HORIZON NUCLEAR POWER LIMITED DEVELOPMENT CONSENT ORDER EN010007

RESPONSE BY NATIONAL TRUST (20010995)

ISSUE: Deadline 5 Response

Figure 4-1 Marine facilities

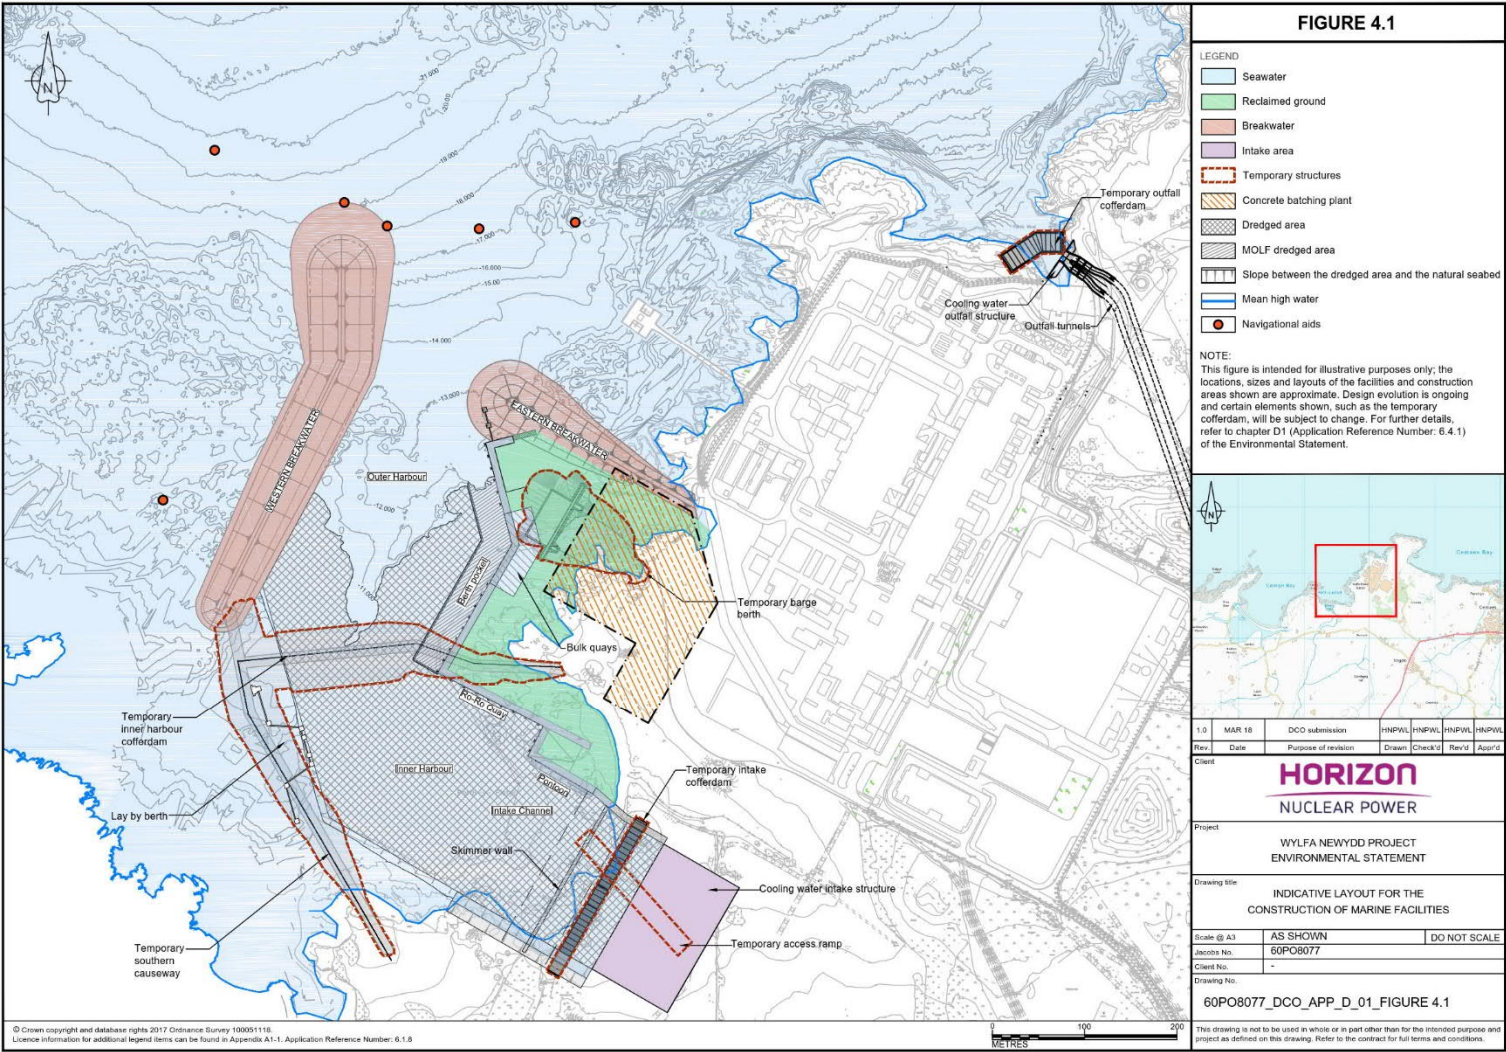
4.1. National Trust remains concerned about the lack of detailed proposals for the protection of its shoreline between Felin Gafnan and Trwyn Pencarreg, which adjoins the WNDA. These concerns relate to the development as a whole (breakwater construction, harbour dredging, MOLF construction) but particularly in relation to the establishment, operation and removal of the temporary causeway. This shoreline is shown in the south-west (bottom left) of the attached plan (Figure 4.1 in the Construction Method Statement [APP-136], page 33). The removal of the temporary causeway has the potential to damage the intertidal biotopes of the shoreline, smothering surfaces, interfering with filter-feeding biota, and potentially introducing pollutants to a currently pristine marine environment.

4.2 The Shoreline Protection and Restoration Method Statement in the D4 Ecological Enhancements Mitigation Report (REP4-023) provides insufficient detail on working practices to reduce the risk of environmental impacts on this shoreline. The Method Statement covers activities within the WNDA (DCO) boundary and does not refer to actions required beyond the boundary. Given the nature of the construction and restoration activities, these will inevitably have impacts beyond the DCO boundary, including the National Trust shoreline which, in places, is less than 100m away at low tide. National Trust is looking for physical, chemical and biological monitoring of its shoreline in order to detect environmental change caused by, for example, pollution incidents/impacts, sediment deposition, and marine litter. Given the approach taken by Horizon to exclude these impacts, it is assumed that such aspects can only be taken forward within a Section 106 agreement. To date the issue has not been identified by Horizon.

4.3 Although National Trust welcomes Horizon's proposal to restore the biotopes of the seabed following removal of the temporary causeway (paras 7.2.1 - 7.2.20, pages 31-37), it is this activity which has the greatest likelihood of impact on the National Trust shoreline. More detail is required on proposed method statements and working practices, in particular the role of the Ecological Clerk of Works and their ability to work outside the WNDA. These details need to be in controlled documents, such as the Marine Works sub CoCP [REP2-033], or through the Section 106 Agreement. This must include procedures for both the required monitoring outside the WNDA and measures to be taken to rectify any impacts,

4.4 NT are concluding from the submissions and clarifications provided by Horizon to date that they are seeking to exercise harbour functions over the area seaward of MHW, but are not seeking to acquire any land owned by National Trust in this area. It would be helpful if this aspect could be clarified by Horizon at deadline 6; clarify how they envisage this sensitive interface between land and sea will be managed both during construction and operation; and provide a detailed drawing of harbour authority boundaries at this juncture.
